## **REFUSAL OF PLANNING PERMISSION**

APPLICATION NO. 2017/1311

**Proposal** Erection of 1 no. bungalow

**At** Land at Meadow Crescent, Royston, Barnsley, S71 4DH

00_Proposed Ground Floor
1:100

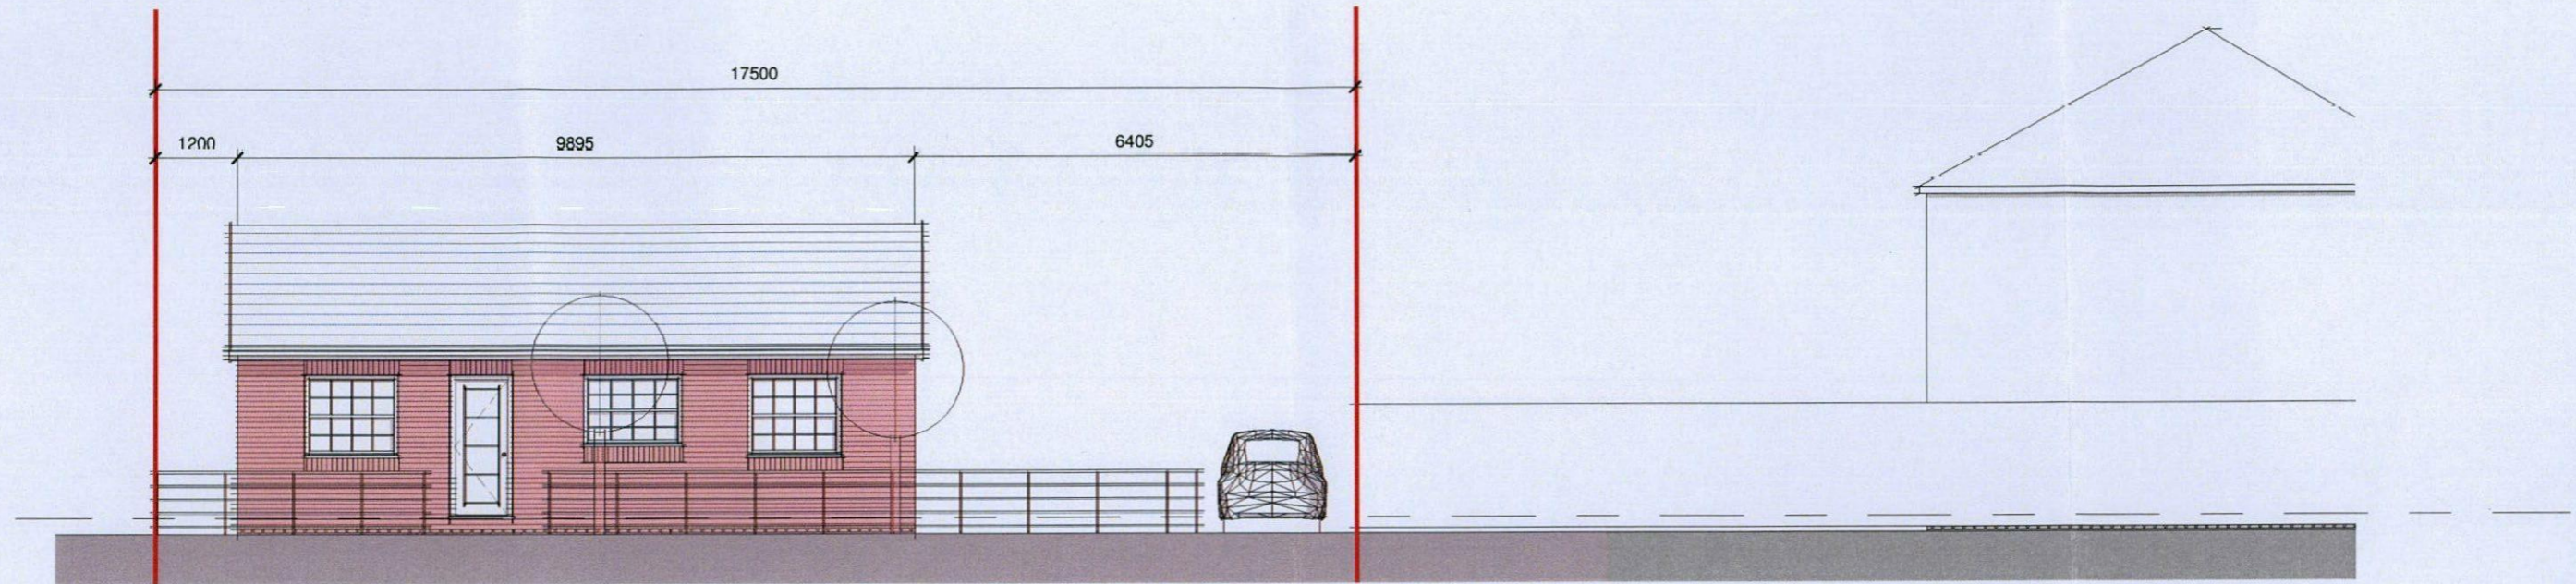
- 2 In the opinion of the Local Planning Authority, the proposed development is contrary to saved UDP Policy H8D, Core Strategy Policy CSP29 and the Council's Supplementary Planning Document 'Designing New Housing Development' in that the proposed dwelling would be materially detrimental to the amenities of the adjacent properties by reason of a loss of privacy, overbearing impact and disturbance from increased residential activity. In addition, the close relationship to adjacent dwellings and their habitable room windows would mean that the proposed dwelling would suffer from substandard privacy and outlook.

- 3 In the opinion of the Local Planning Authority, the proposal would represent over development of the site, in that there is insufficient space to provide adequate private amenity space, contrary to the Council's Supplementary Planning Document, Designing New Residential Development and CSP29 of the Core Strategy.

00_Site Plan
1:500

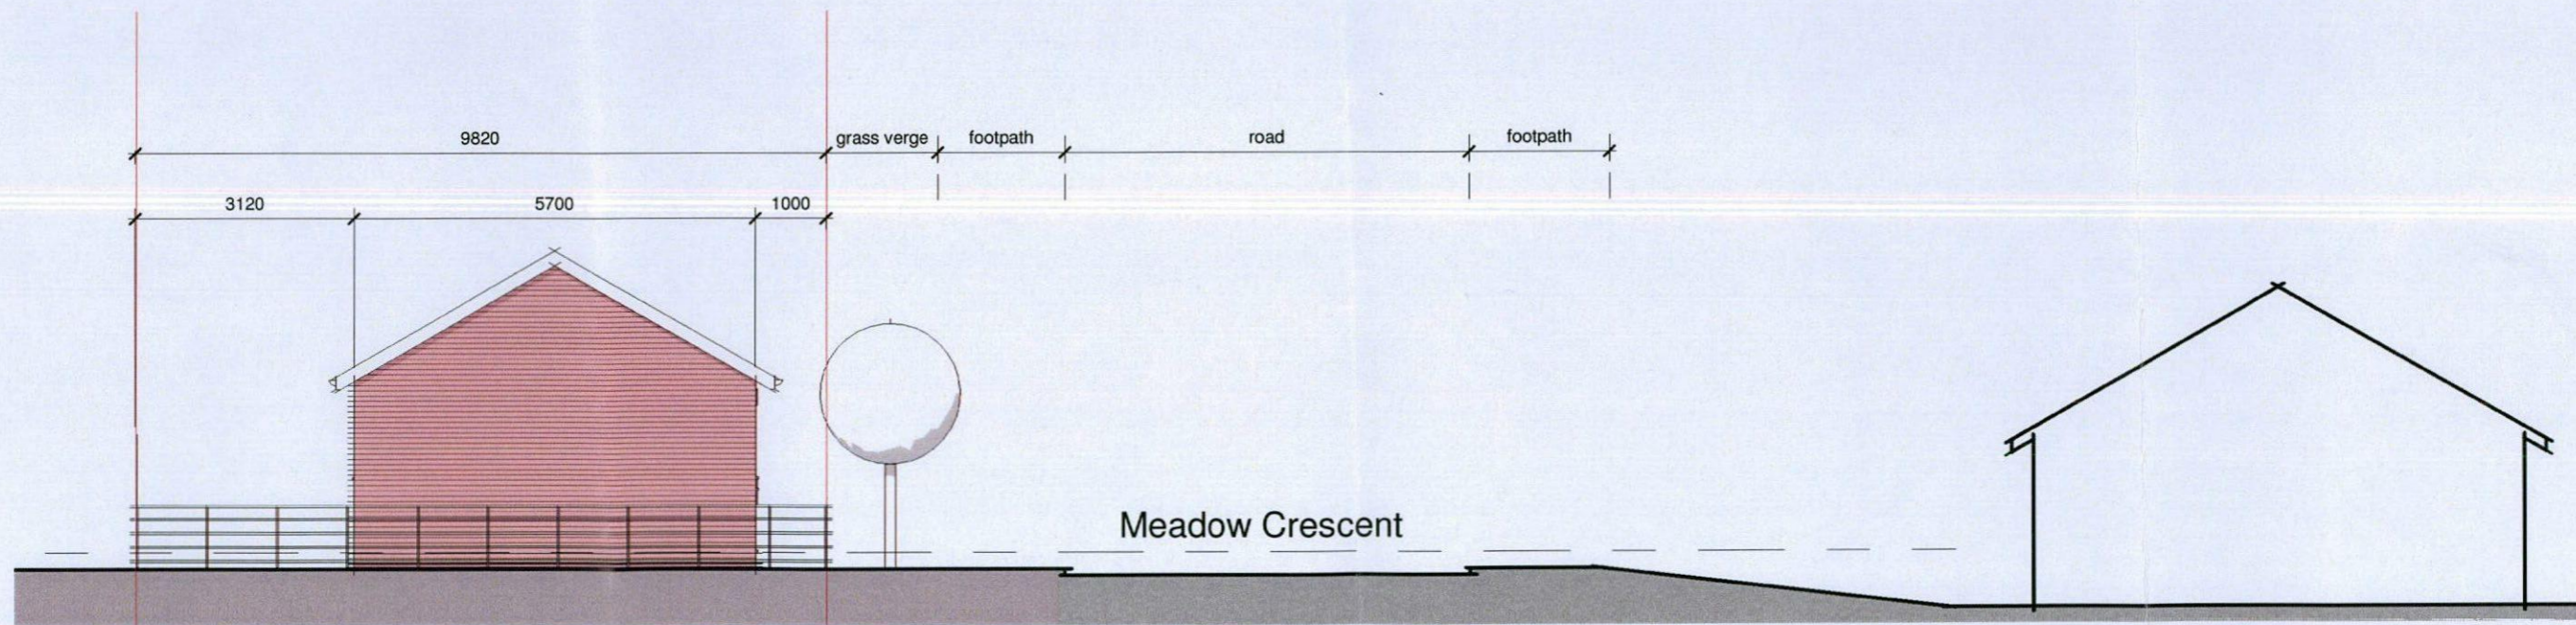
- 1 In the opinion of the Local Planning Authority the proposed dwelling would be contrary to saved policies H8A and H8D of the Unitary Development Plan, Core Strategy Policy CSP 29, the Council's Supplementary Planning Document 'Designing New Housing Development', and the NPPF, in that the small size and confines of the application site, and relationship with adjacent properties, means that any dwelling would appear cramped within this restricted site. The proposal therefore represents an undesirable form of infill development and as a consequence, would emerge as an incongruous feature in the street scene to the detriment of visual amenity.
